Recommendation Report for Planning Permission for Works or Extension to a Dwelling

REF NO: P/44/21/HH

LOCATION: 12 Mallard Crescent
Pagham
P021 4UU

PROPOSAL: Garage conversion with replacement conservatory & internal alterations.

Title: Proposed South & East Elevations  
 Site: Mallard crs  
 Scale: 1:100 @ A4  
 Dwg No: 005

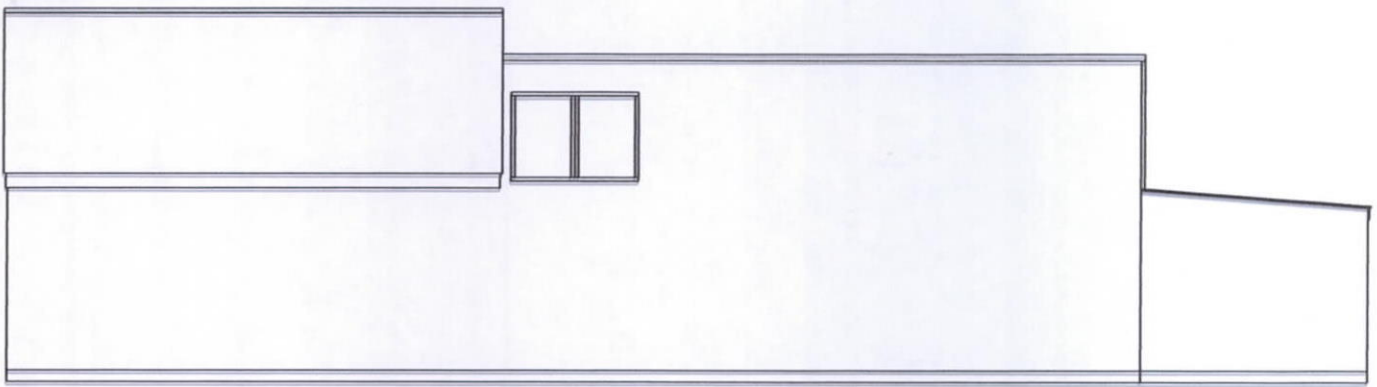
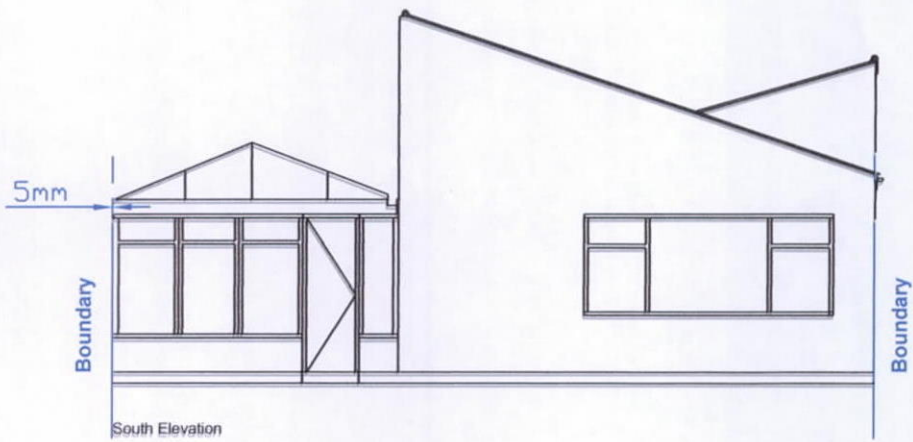
The glazed extension will have a hipped roof and it will reduce to form a flat roof to the rear over the garage. Whilst the addition will add bulk to the side of the dwelling, the height is set below that of the host dwelling and as such appears as a subservient addition.

The materials will be of a typical conservatory with glazed walls and white uPVC structure. It is not considered to be out of character with the existing dwelling

Title: Proposed North & West Elevations
 Site: Mallard crs
 Scale: 1:100 @ A4
 Dng No: 006

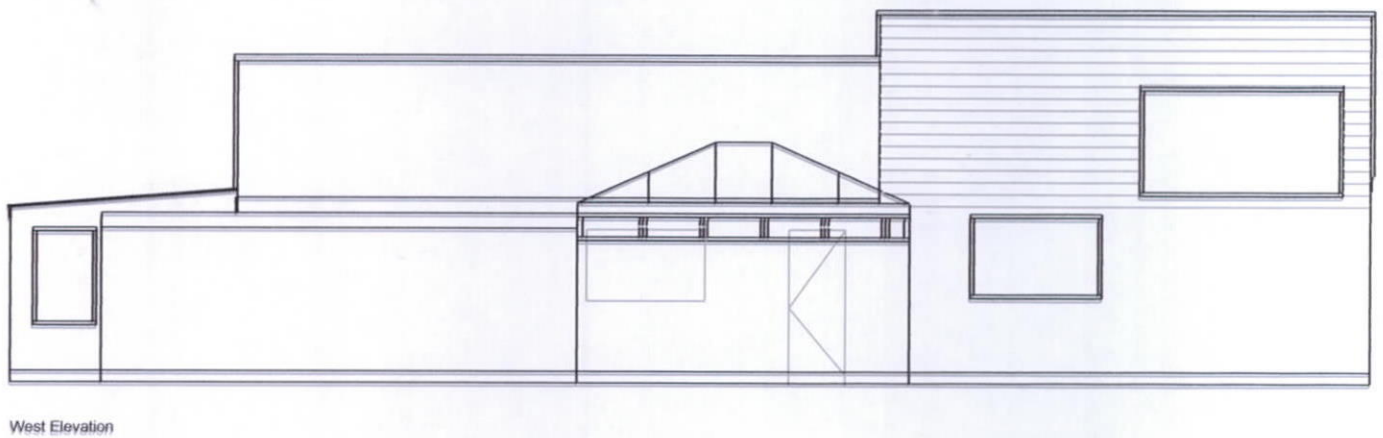
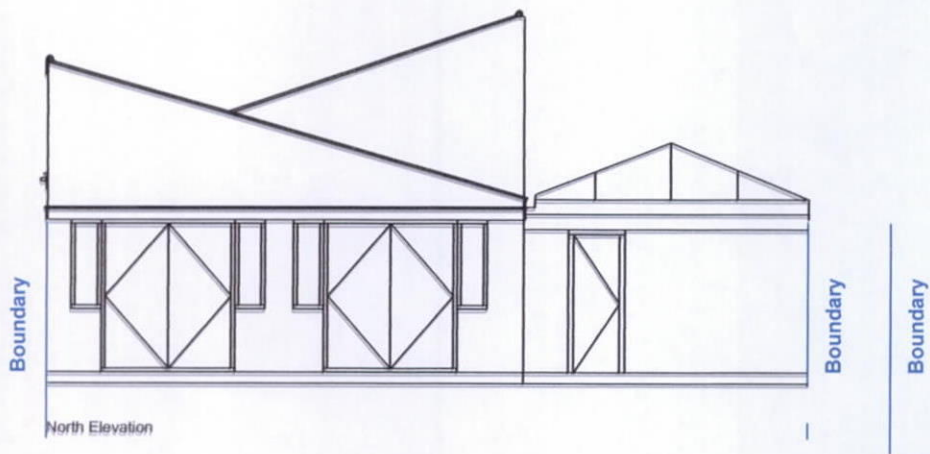
The addition will extend to the western side of the dwelling with a width of 3.63m. This will run along approximately the rear half of the full side elevation.

The front of the extension will be pitched to a height of 3.3m. This will reduce to around 2.3m as it reduces to form a flat roof as it extends along the rear over the garage.

This meets with the boundary to the west. Due to the siting, with sufficient distance retained to the side of the neighbouring property, it is not considered to appear overly dominant or overbearing upon amenity. In the event of an approval for this application a condition would be applied to obscure glaze the side of the conservatory facing the neighbours property and for all windows in that elevation to be fixed shut

There will be a glazed wall to the western side elevation, It is considered that a condition to ensure that the glazed wall is obscure glazed and its windows fixed shut is necessary to ensure the privacy of the next door property is maintained.

Reason: For the avoidance of doubt and in the interests of amenity and the environment in accordance with policy D DM1 of the Arun Local Plan.
- 3 The fenestration on the western elevation of the conservatory shall at all times be glazed with obscured glass and the windows in that elevation fixed to be permanently non-opening.
